CLIENT:	Strata Sterling Barnsley West Ltd
PROJECT:	Barnsley West
SUBJECT:	Clarification Note in Response to Consultation Comments Made by Barnsley Metropolitan Borough Council's Forestry Officer
JOB NO.:	LD10848
DATE:	30 th May 2024 Revised 18 th June 2024, Further revision 4 th July 2024
PREPARED BY:	Second revision prepared by Alan Reid – Principal Arboriculturist Revision prepared by Kelly Stewart – Senior Arboriculturist
REVIEWED & APPROVED BY:	Moray Simpson – Technical Director (Arboriculture)

1.1.1 Wardell Armstrong (WA) was commissioned by Strata Sterling Barnsley West Ltd to provide clarification comments in response to comments made by Barnsley Council's Forestry Officer in December 2023. Note, this note does not provide clarification on ancient woodland matters, this has been addressed in a separate note, also produced by WA.

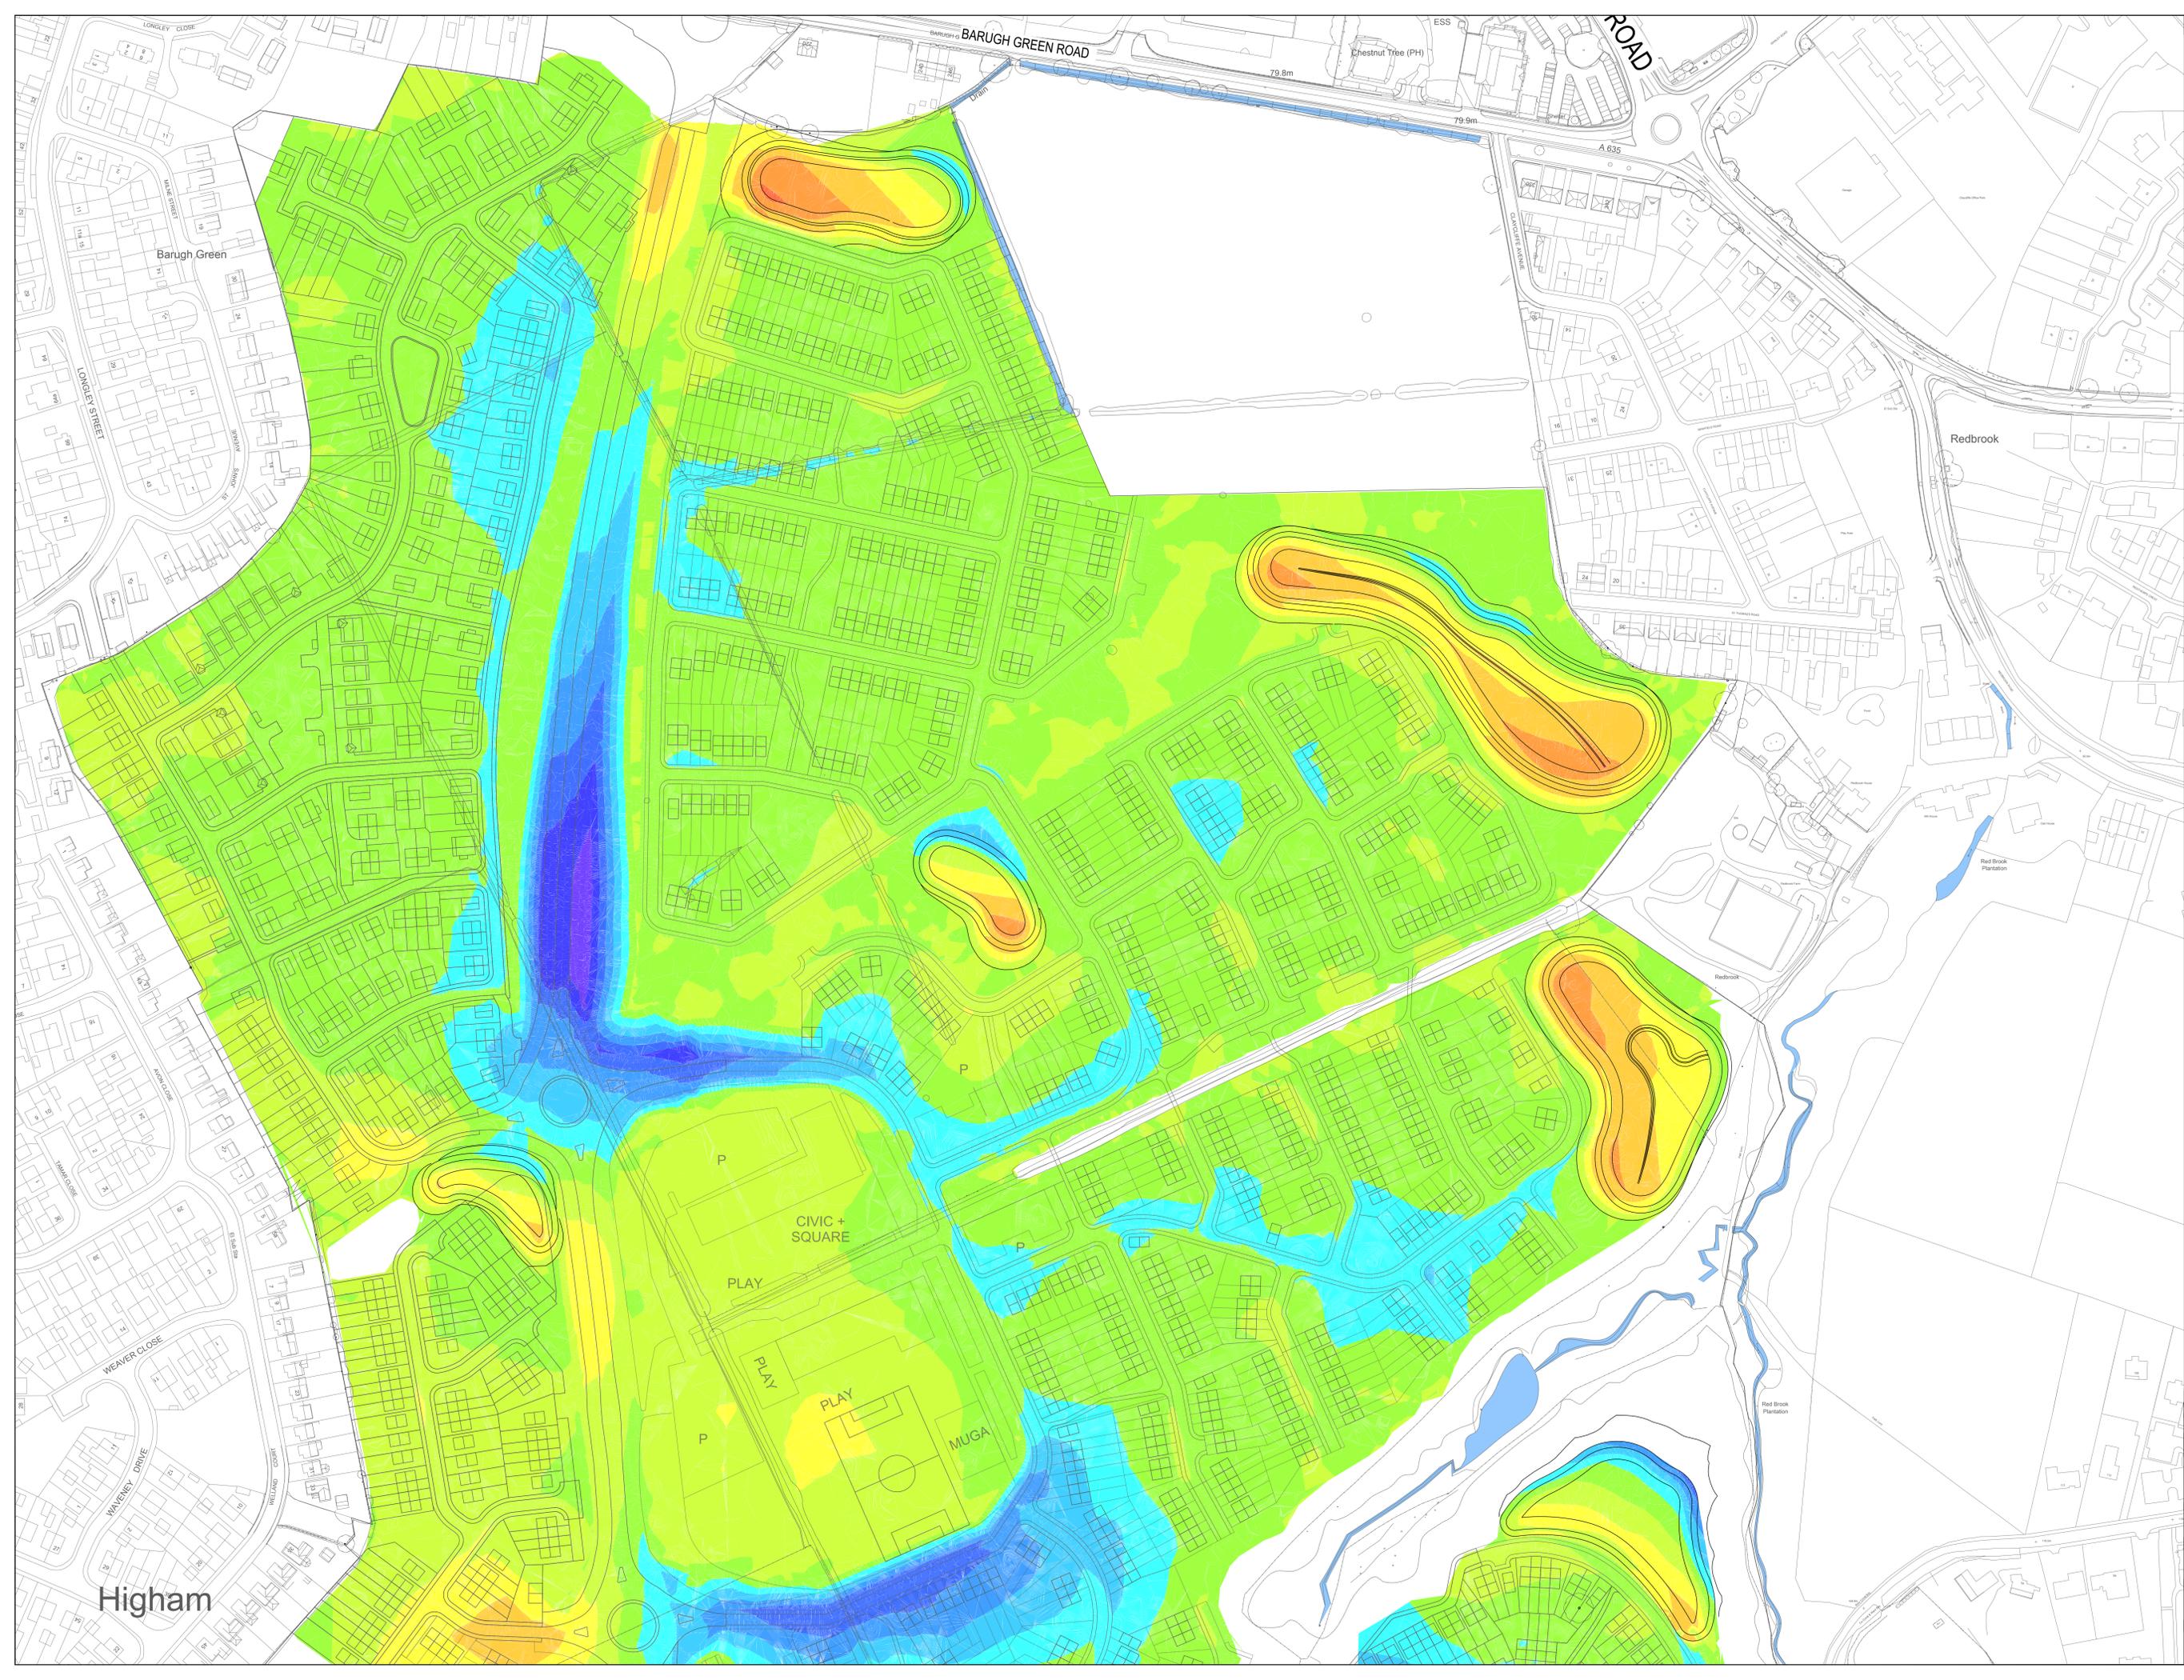
1.2.2 *'The proposals do impact on several category A and B trees and groups with regards to level changes, however many of these appear as though with some minor amendments they could be remedied such as for Cat B T31 where level changes are proposed in part of the rooting area, it would therefore seem sensible to amend the extent of the level changes where possible where trees are on the edges of these works so as to minimise as far as possible the loss of these trees. I have also noted that some trees are shown for removal including category A trees and groups which are shown in areas of open space such as T49, T126 and G102 due to level changes. I would therefore again question ground level changes in some of these areas and how necessary they are given these areas are not to be built on. I am fully aware that in*

2.3.4 In relation to the individual tree queried by the Tree Officer, tree T31 cannot be retained due to a ground level increase of up to 2m, covering approximately 50% of the tree's RPA.

- Masterplan Cut/Fill Depth To Existing Ground Level Sheet 1 Ref. QD2088-00-302 by Queensbury Design;
- Masterplan Cut/Fill Depth To Existing Ground Level Sheet 2 Ref. QD2088-00-303 by Queensbury Design.
